From: ENVU Biodiversity and Land Use
Sent: 09 February 2026 10:26
To: Planning ContactCentre
Subject: 2025/93572 at location Land South of, Barnsley Road, Upper Cumberworth, Huddersfield, HD8 8NN

Please see ecological commentary below:

Layout For Illustration Purpose Only.

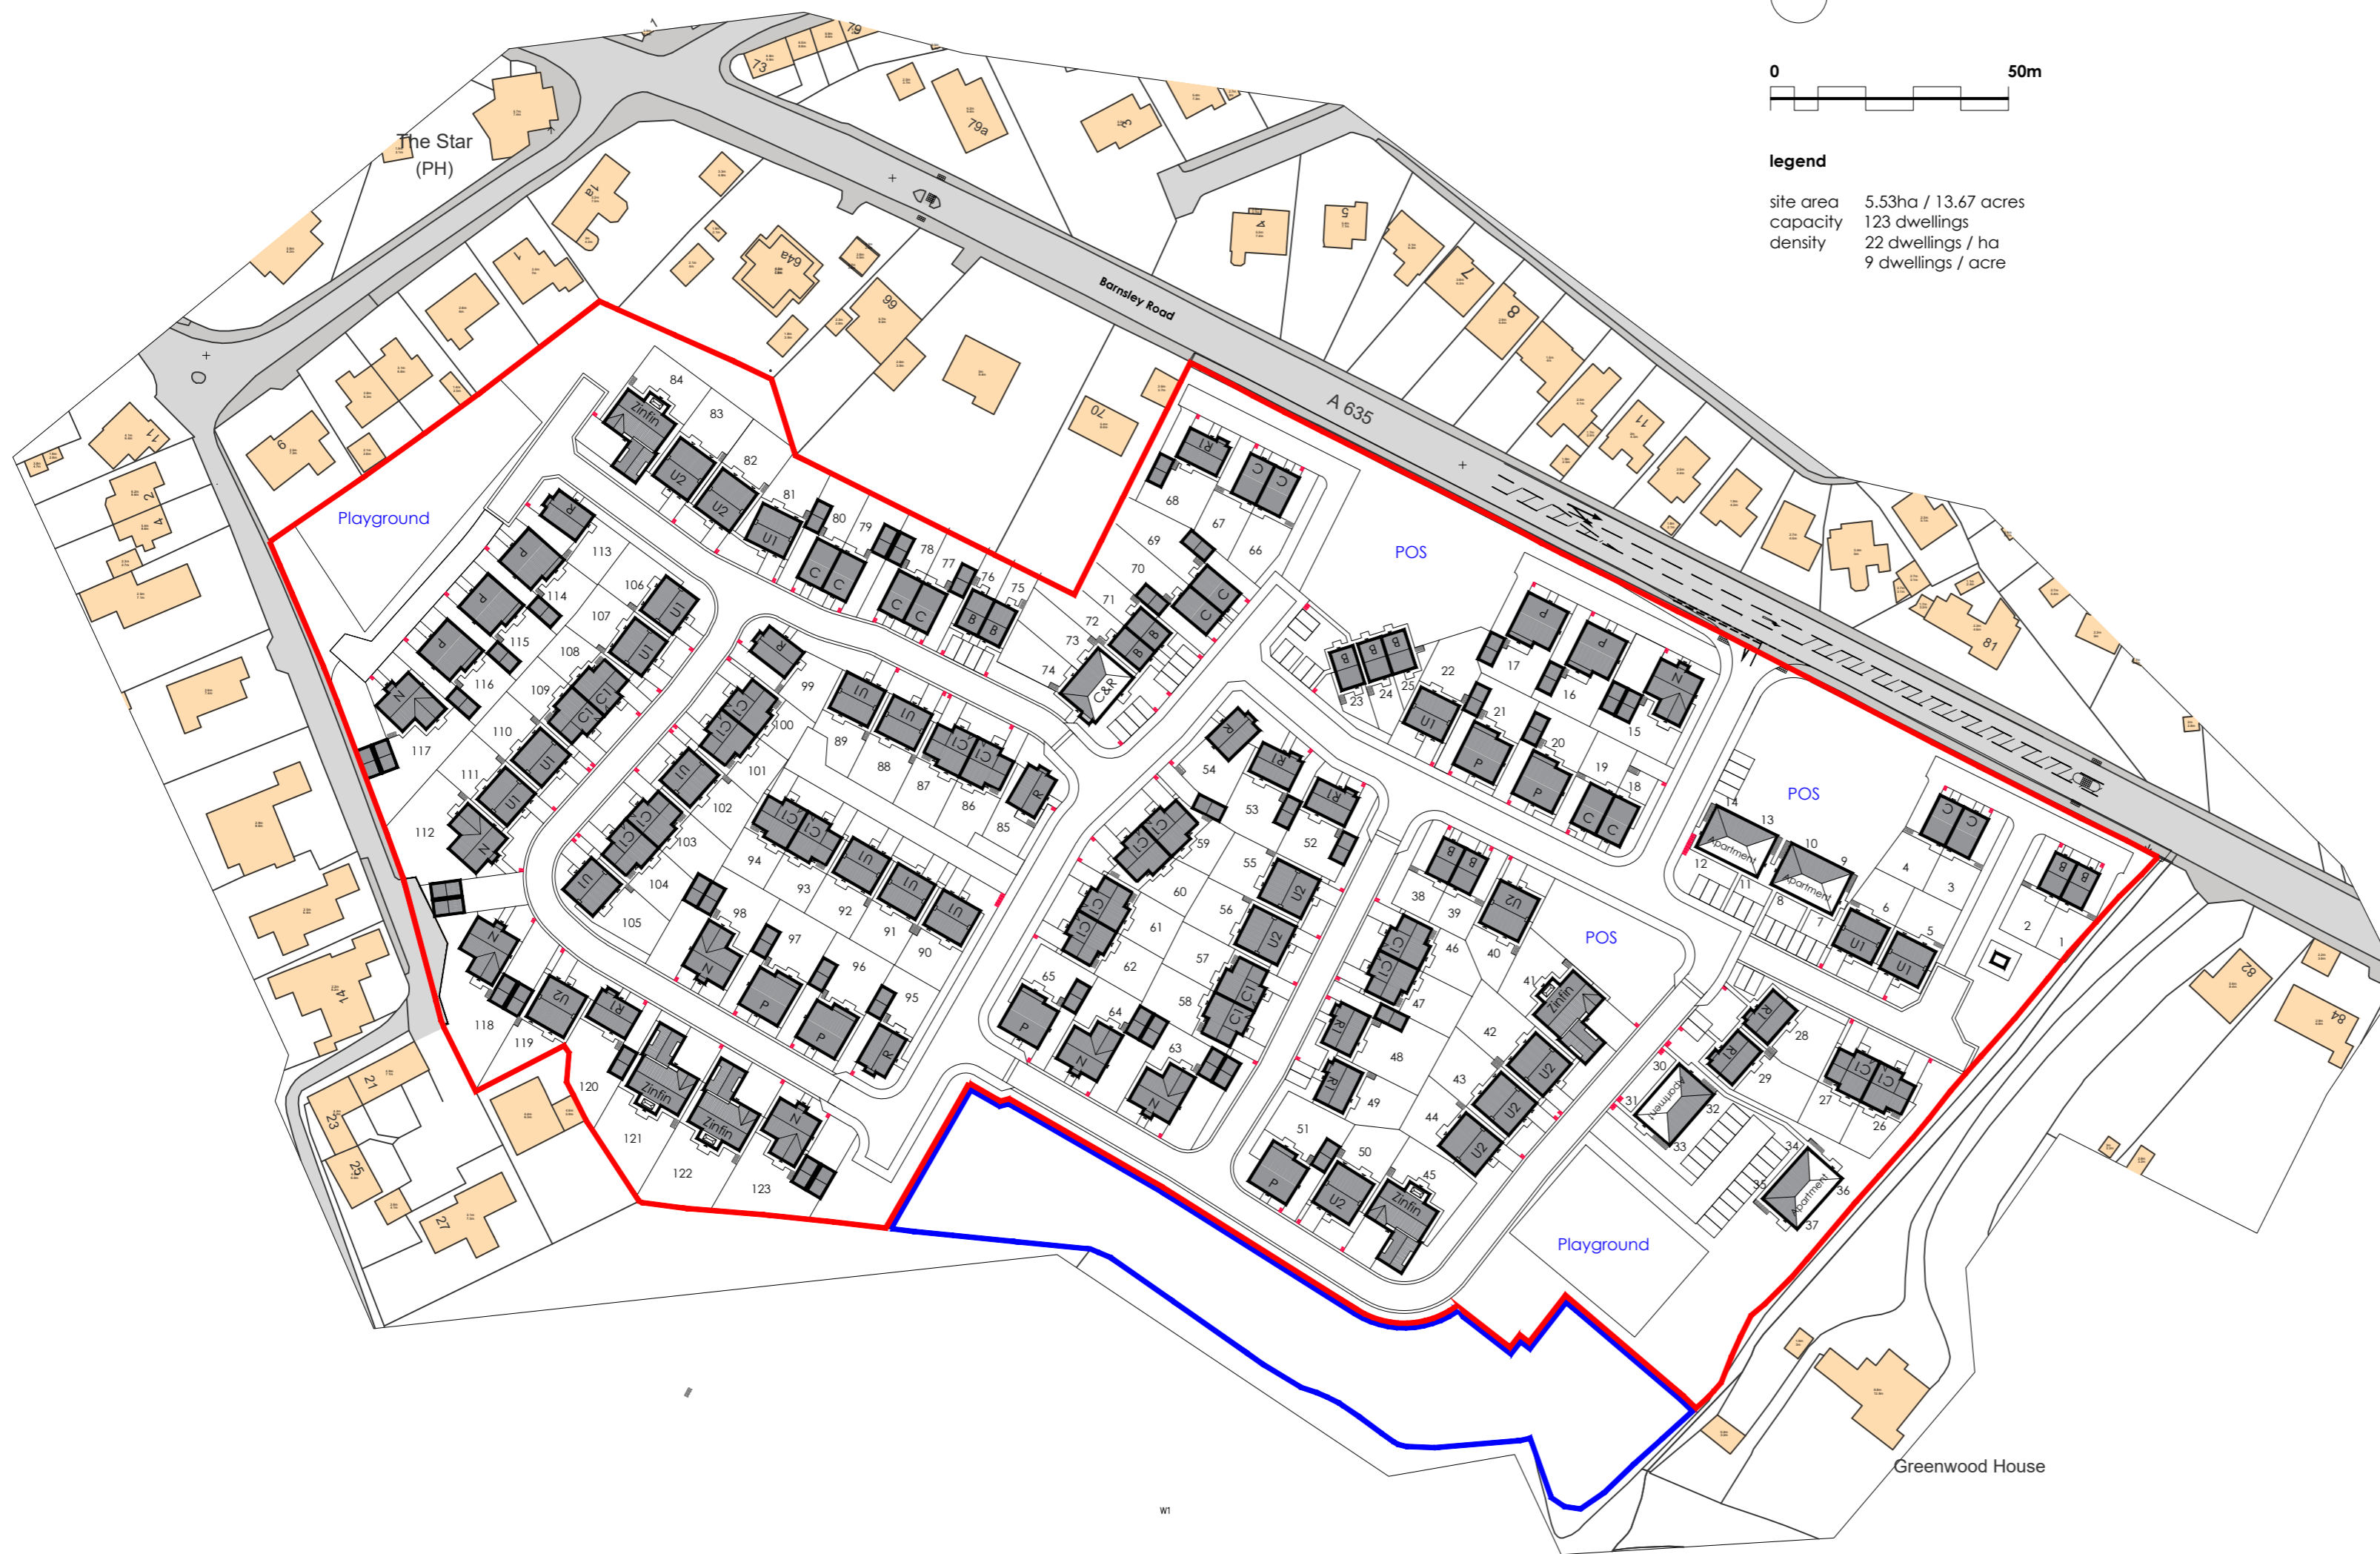
The site itself consists of buildings, grassland, cereal crops, mature trees, hedgerow, and hardstanding. The site is adjacent (southeast boundary of the site) to a priority woodland habitat, which has the River Dearne flowing within it – and is deemed a significant wildlife corridor. A 15m buffer from this area is mentioned, which is the absolute minimum buffer required for a development. **However, it can be argued that this development is considered a major development (>10 homes; >0.5ha) and so it could be requested to increase the buffer to 30-50m. As a result, the applicant should review their designs to increase the buffer in the southeastern boundary.**

- Trees – there are large and medium mature rural trees (T1) within the site. All trees onsite (T1) and the trees / hedgerows on the eastern boundary will have tree protection conditions applied. **It is not clear in the current design that T1 trees to the west of the site are to be retained. The design should be reviewed to retain them. It is not current agreed / permitted for these trees to be removed.**

- BNG conditions to be provided once clarifications are reviewed
- T1 trees to west of site to be retained, design to be reviewed and further commentary will then be provided.
- Buffer to 30-50m to be considered for southeastern boundary.
